Conservation and Urban Design Advice

Reference: X/23/0456/CND

Site address: Brickhouse Farm, Church Lane, Hunsdon, Hertfordshire, SG12 8LG

The application is for "Discharge of Conditions 3 (Materials), 4 (Sustainability) and 7 (Bat boxes) of Planning permission 3/22/2068/FUL". Comments are set out below on the relevant condition.

Title: **Proposed Plans, Elevations & Sections**

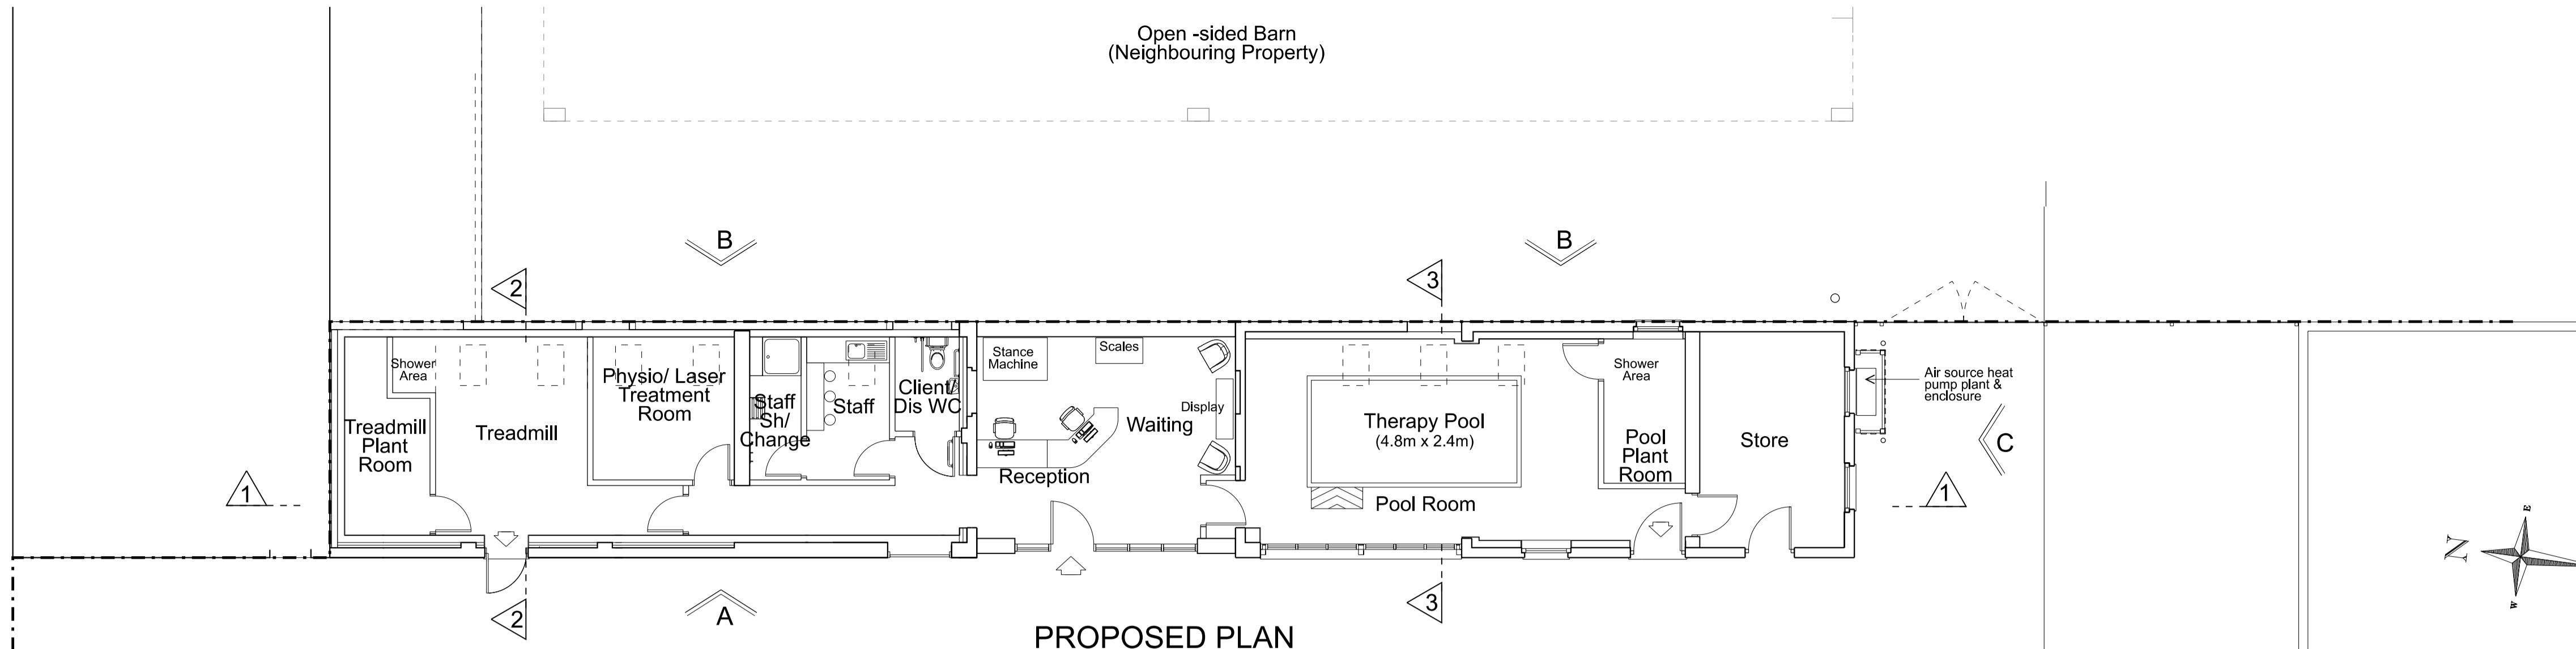
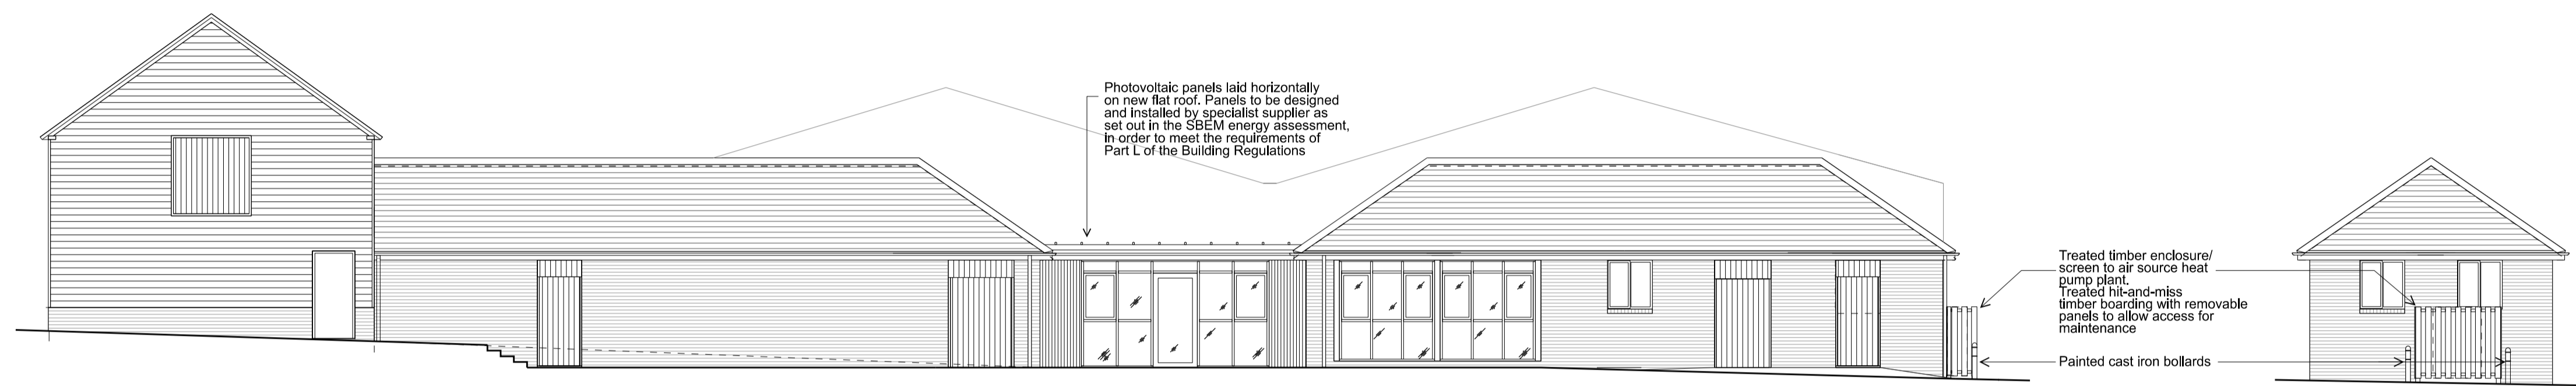
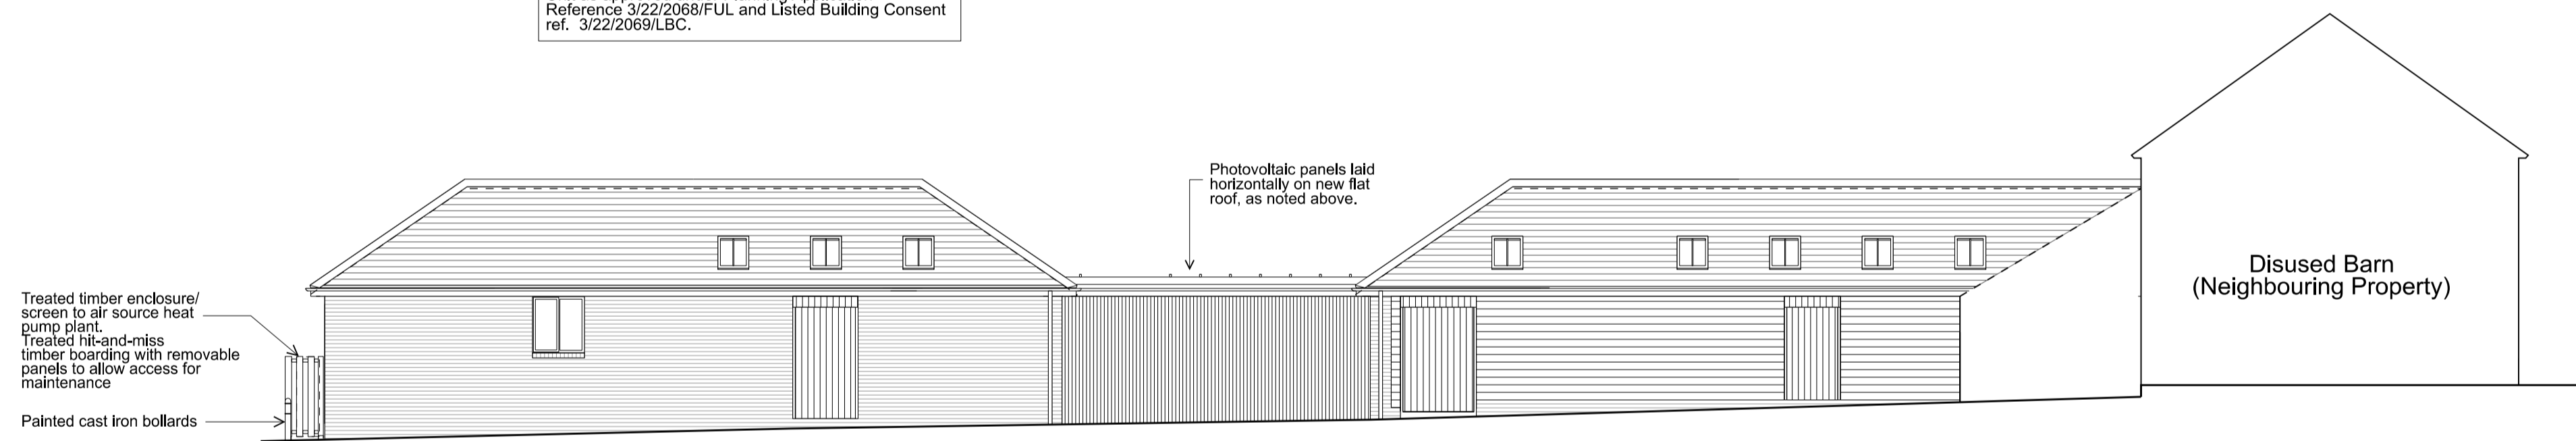
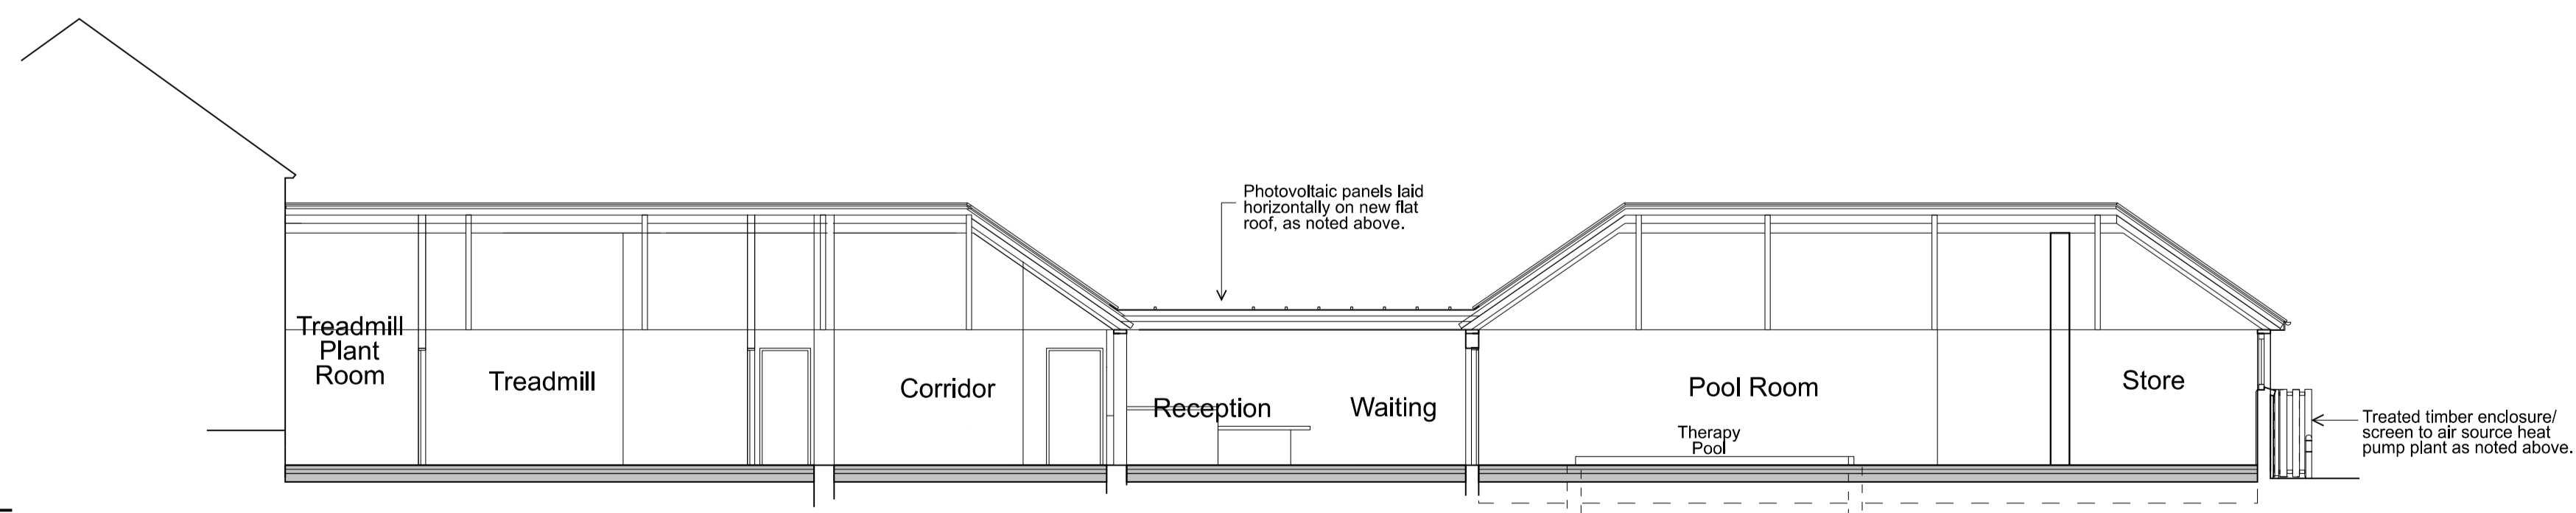
Iberian natural slate is proposed which is not acceptable. British slate should be used which is denser, stronger and durable, making it more suited to the British climate. British slate is also typically less susceptible to rusting, discolouration and cracking when compared to Spanish slate.

The proposed weatherboarding is an acceptable design, however the type of timber should be confirmed.

A photograph has been submitted showing the type of vertical timber cladding which is intended for the link extension. This is acceptable in principle, however the detailed specification for the timber cladding is required.

This condition mentions that an air source heat pump will be installed. This requires planning permission and may require listed building consent depending on if it is fixed to the building. Further information is required.

Extractor fans are referenced. These are likely to require listed building consent and further information is required. It is intended to install a rainwater harvesting system. Further information is required about this as it may also require planning permission or listed building consent depending on if it is fixed to the building.
